From: Sue Howell <Sue.Howell@arun.gov.uk>
Sent: 14 October 2021 15:22
To: Planning.Responses <Planning.Responses@arun.gov.uk>
Cc: David Easton <David.Easton@arun.gov.uk>
Subject: FW: Planning Consultation on: Y/127/21/RES

Application ref: Y/127/21/RES

Description: Approval of reserved matters (appearance, landscaping, layout and scale) following the grant of Y/91/17/OUT for 250 No dwellings with associated parking, road/footway/cycleway provision, open space, landscaping, surface water attenuation & ancillary works (resubmission following Y/152/20/RES). this site is not CIL Liable as in Yapton Strategic Site.

Location: Land at Bilsham Road Yapton

**A SEMI-NATURAL LAP**  
Scale: 1:250

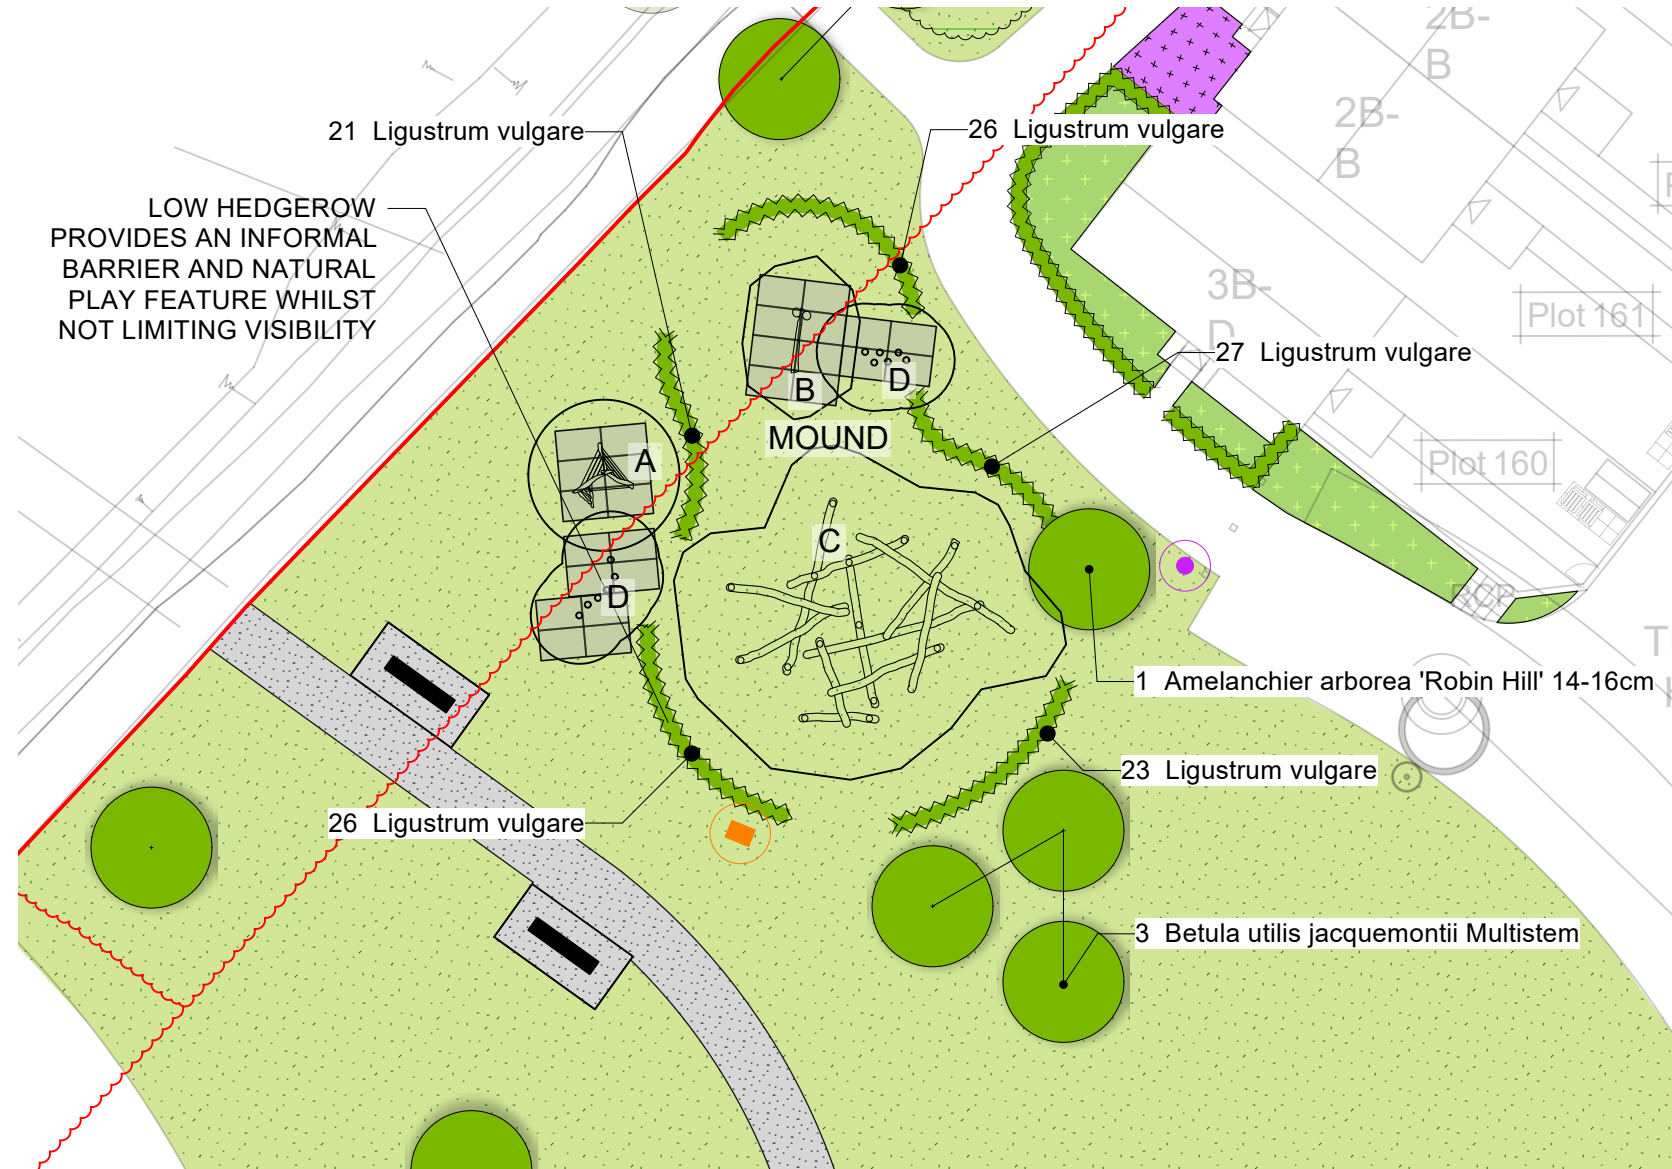
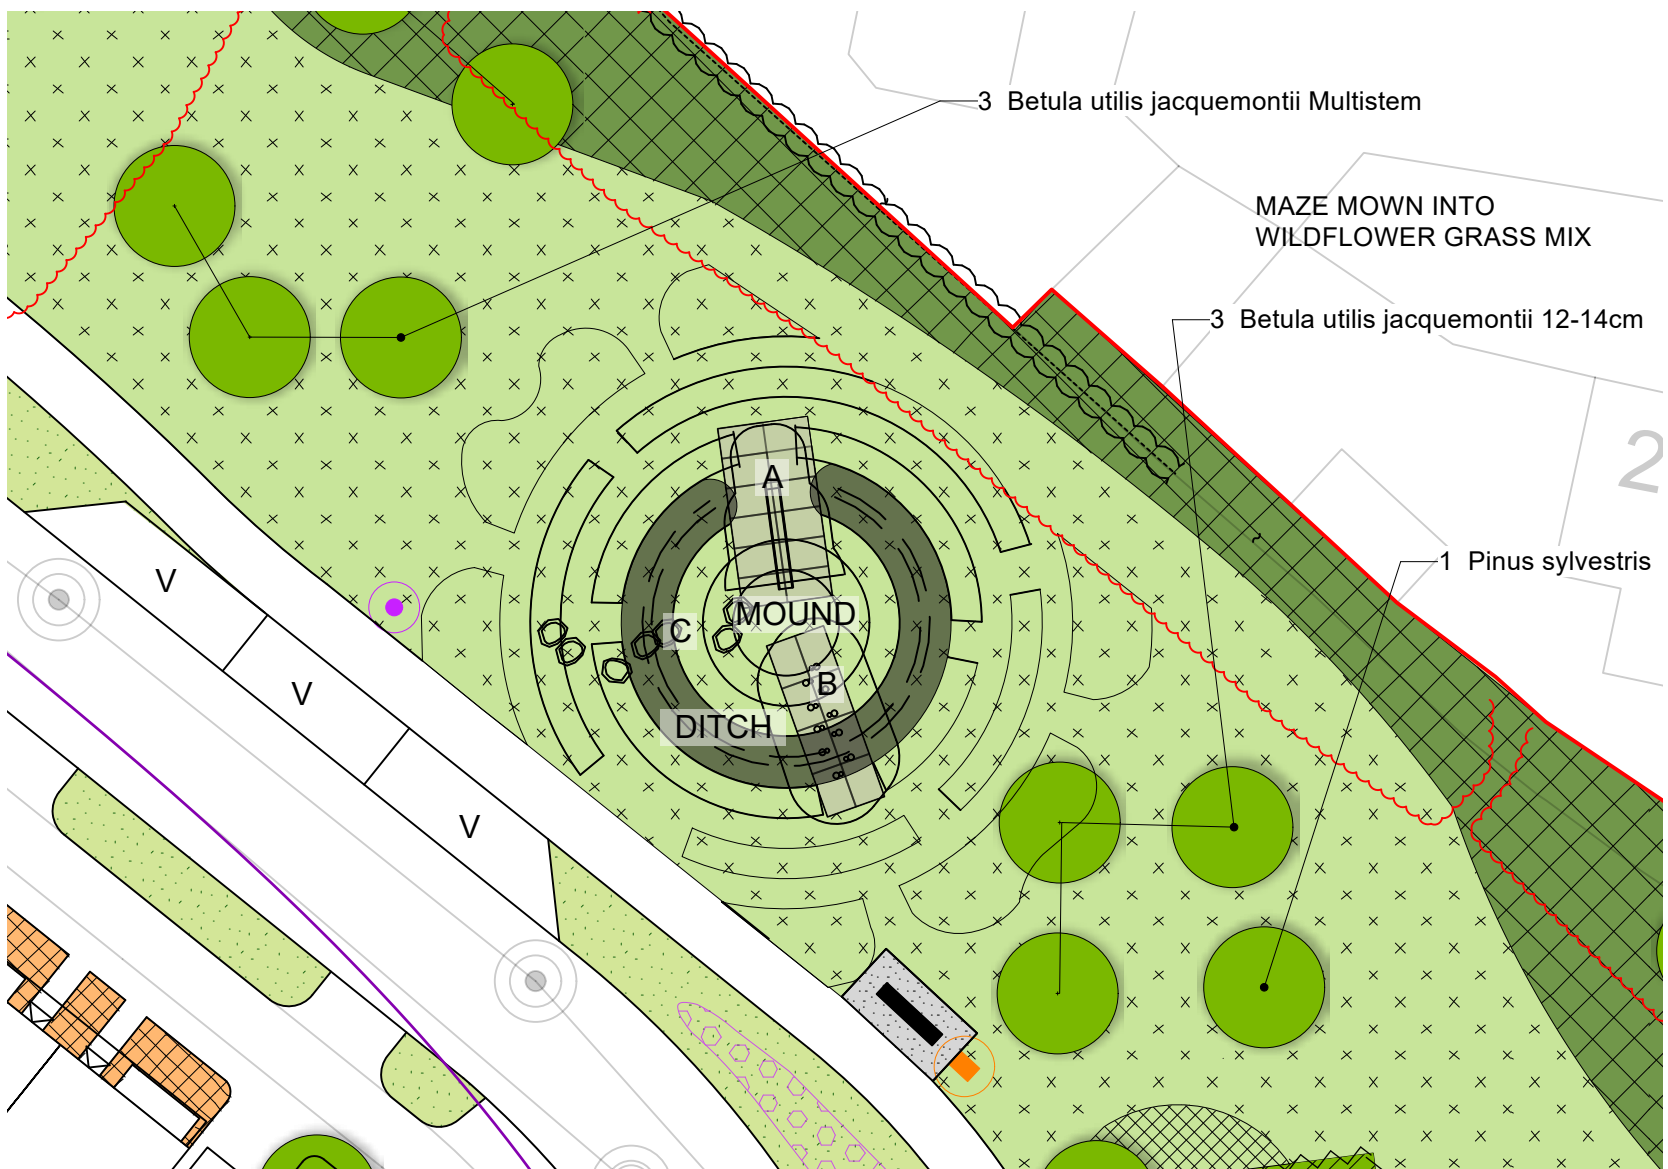
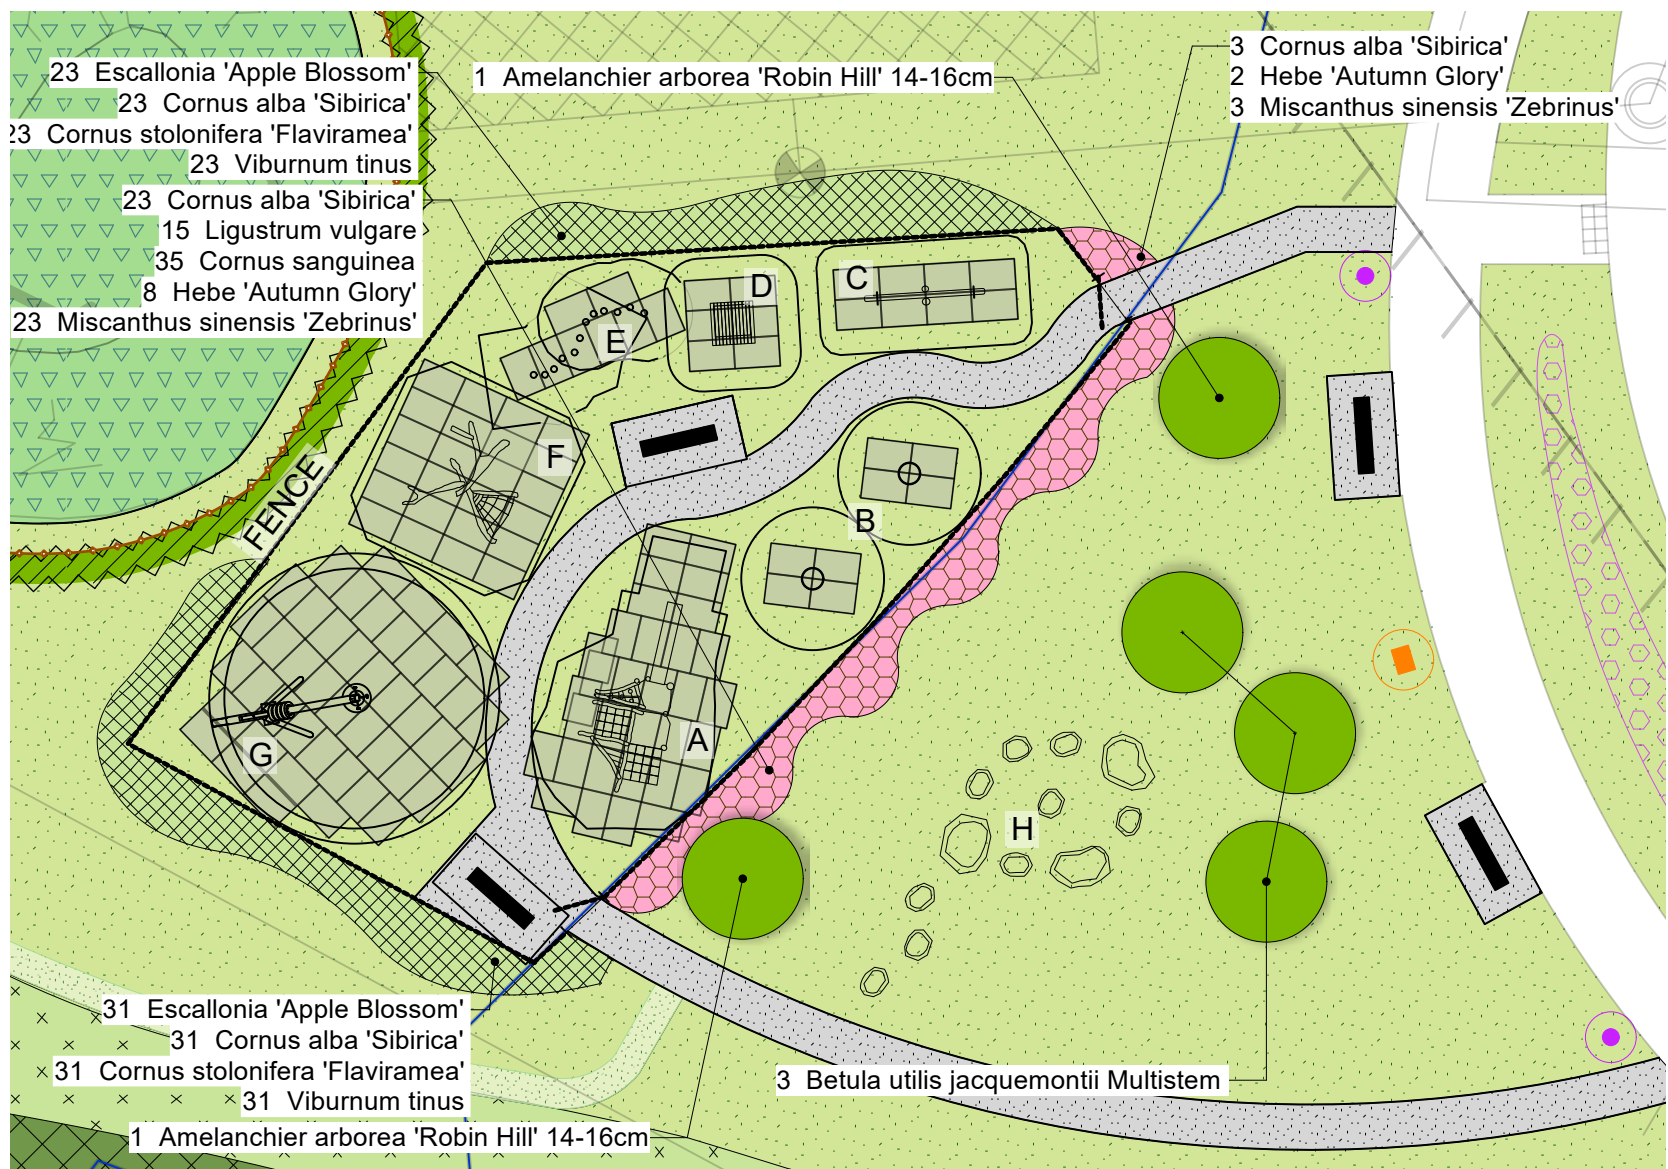
The Landscape proposals Play Spaces dwg Sheet 111 Rev G has provided detail of 2no LAP and 1no LEAP area. These details have proposed a scheme which will provide a variety of formal and informal play with a good mix of play experience. These areas have included suitable connectivity and pathway access with appropriate safety surfacing. Benches outside of the play areas have also been shown which is good to see and provides for all. **Confirmation of the detail and specification for the 'galvanised metal fence to play areas and also post and wire fence to SuDS surrounds should be provided for approval.** RoSPA or similar approval where SuDS in close proximity to play. **Confirmation of the proposed use of the area immediately north of the LEAP and shown as a hatched area pink and detailed as 'other outdoor provision' to be provided.**
